Your Ref: OWPC1423
Our Ref: R/225/13/ 08-10-2013
Please ask for:
Mr C Cronin

Installation of transformer, generator, substation, sprinkler tank and pump house at ground floor level along with rooftop condenser units.

Sainsburys Supermarkets Ltd, Unit C New Road Rustington Littlehampton

Sprinkler Tank and
Pump House details

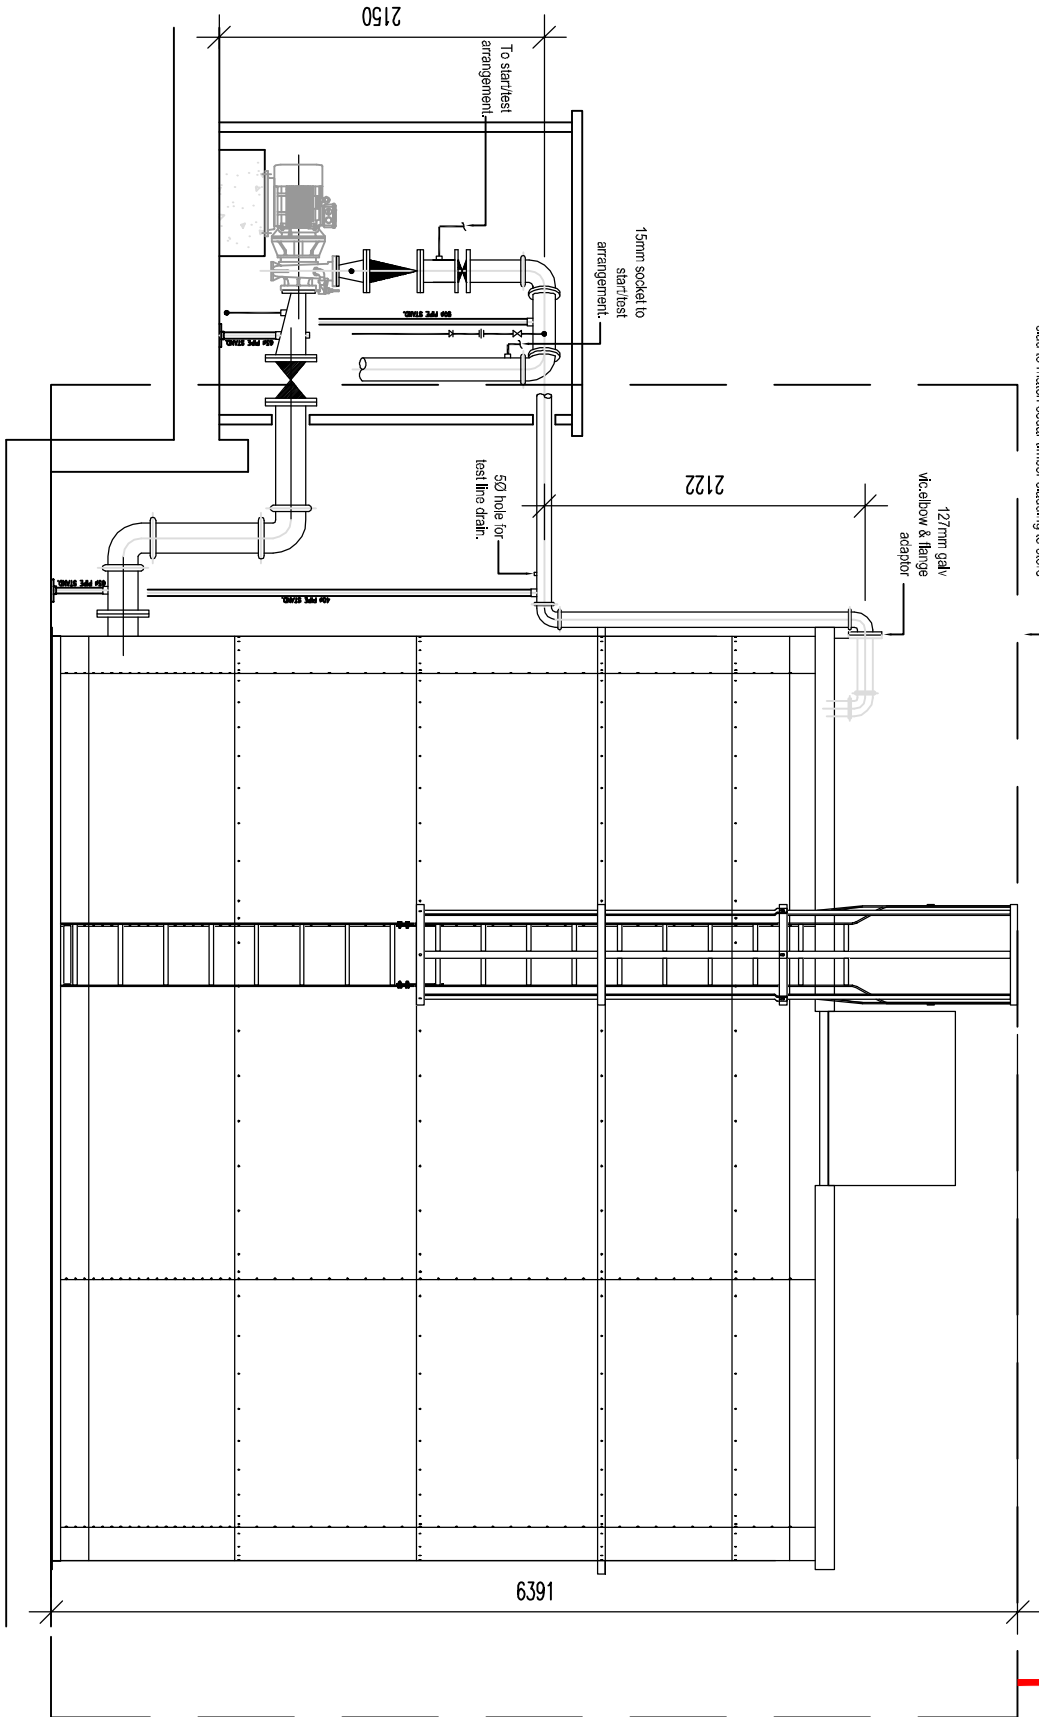
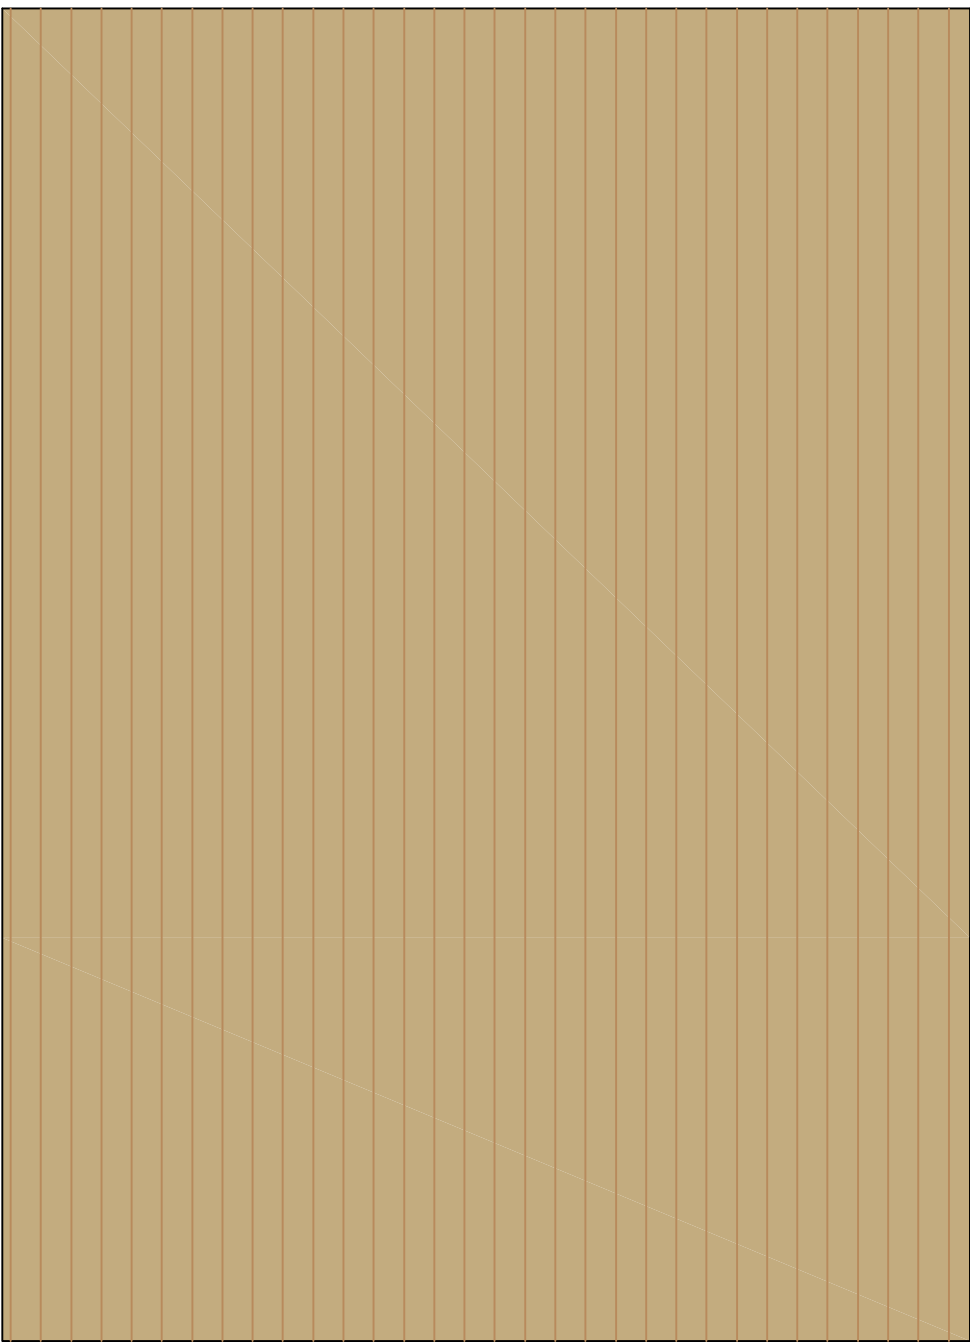
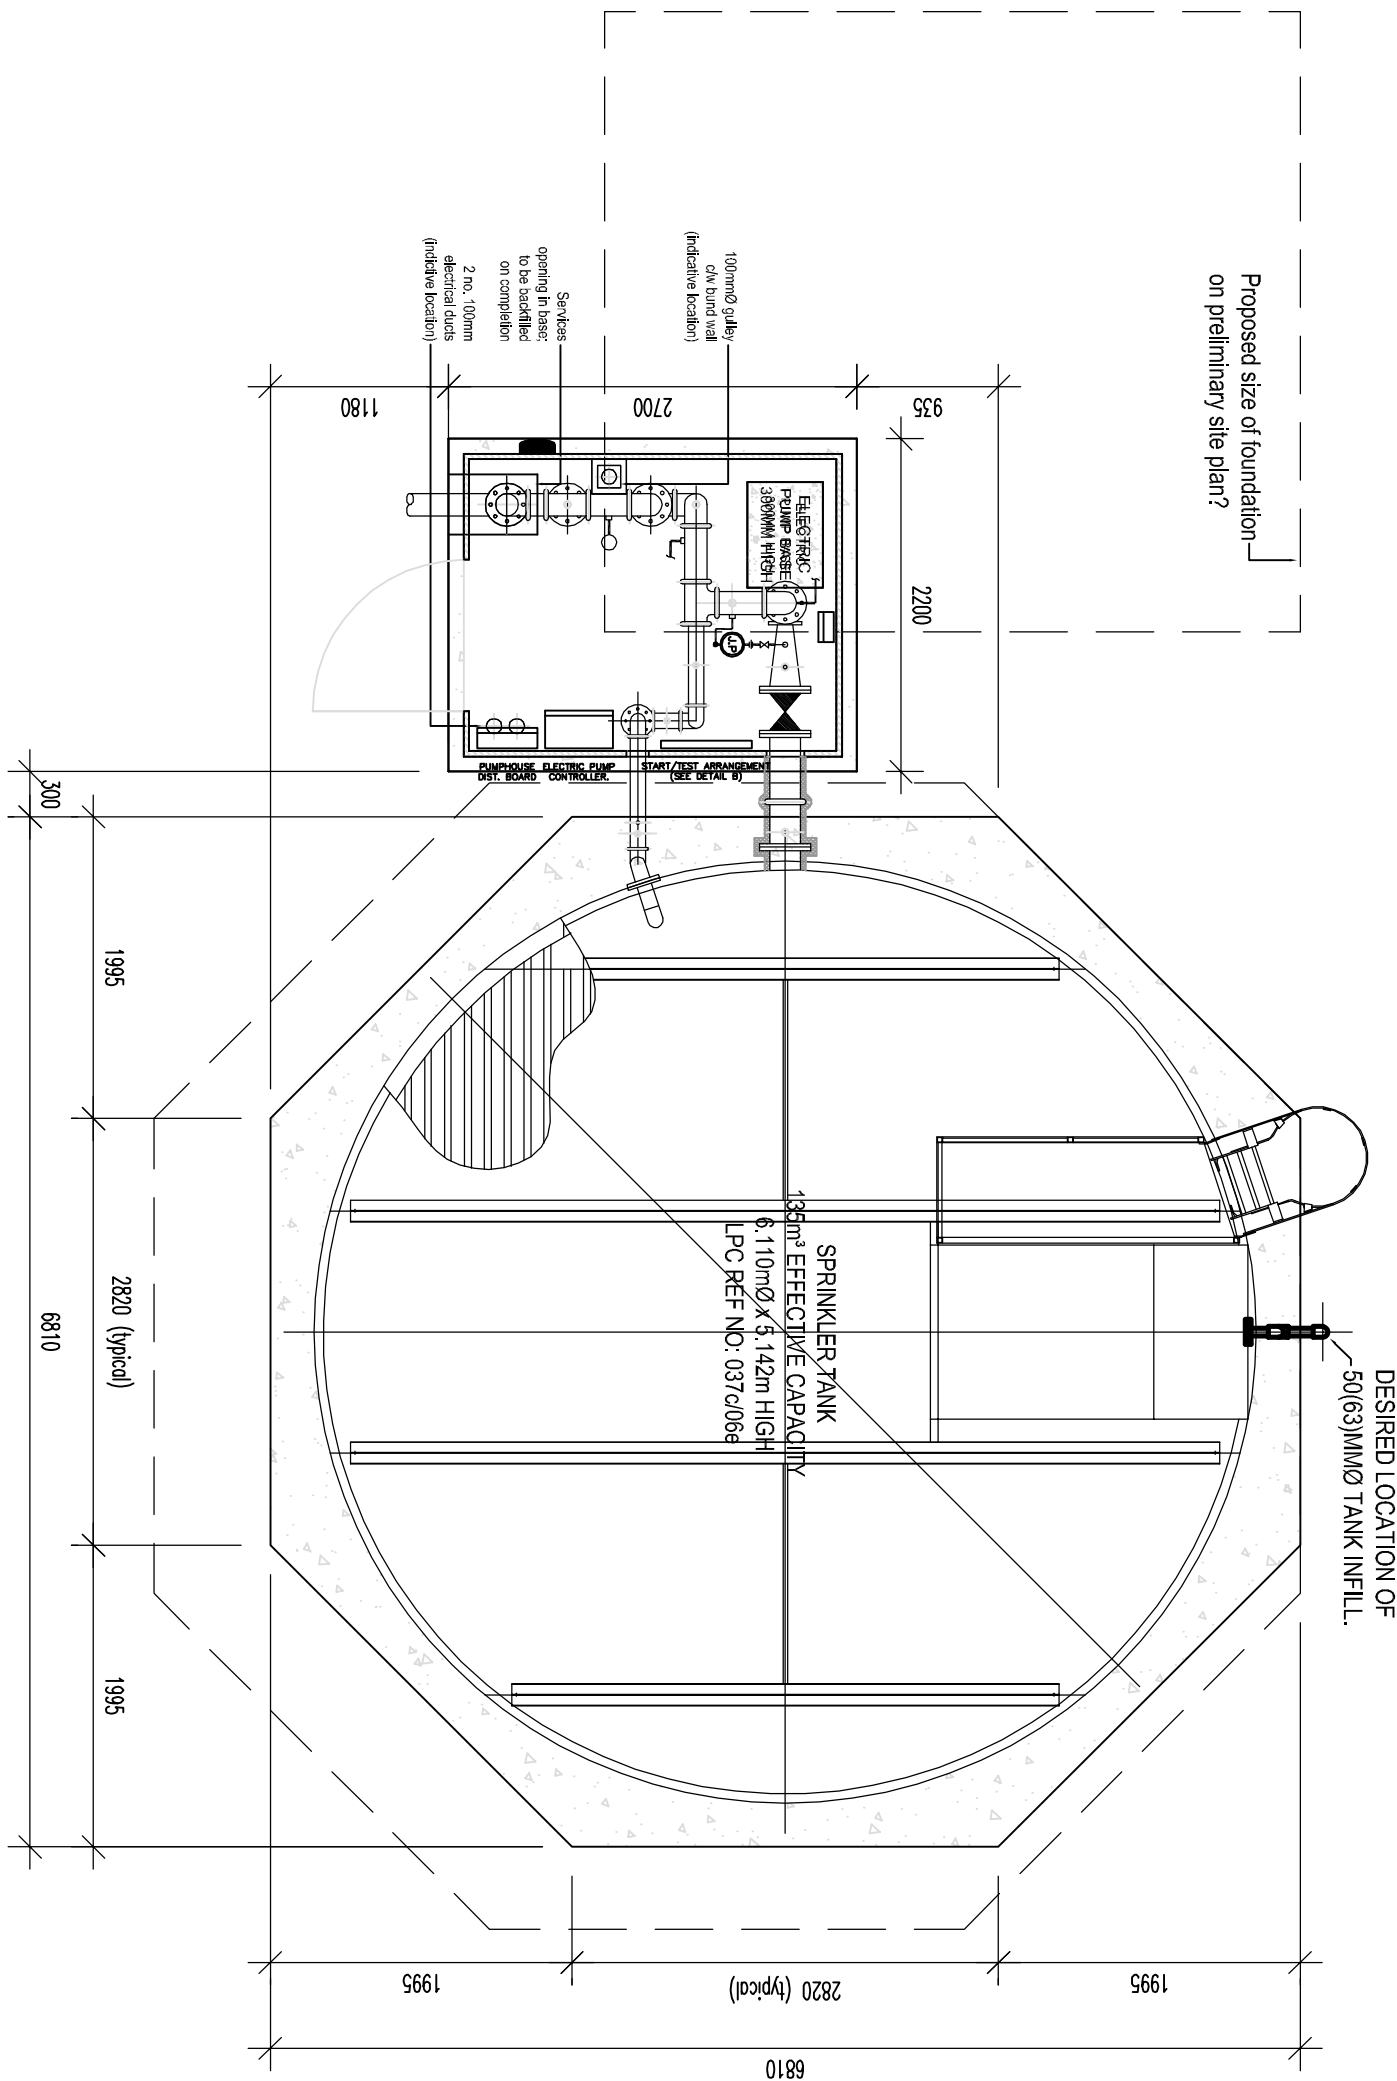
The original application for the installation of the Sprinkler Tank was refused. In the Officers report it was stated "It is not considered that suitable landscaping, screening or minor design changes could mollify the proposal to such an extent as to make it acceptable in planning terms"

The screening that has been erected (again without planning permission) certainly bears out this statement. The screening erected is ugly, overbearing and offensive and has an extremely adverse effect on the environment. I consider that the original refusal for the installation of the tank should stand.

It is not for the Council to suggest a solution to the applicant but I believe they should consider an alternative of installing 2 or more smaller tanks located elsewhere within the boundaries of their site
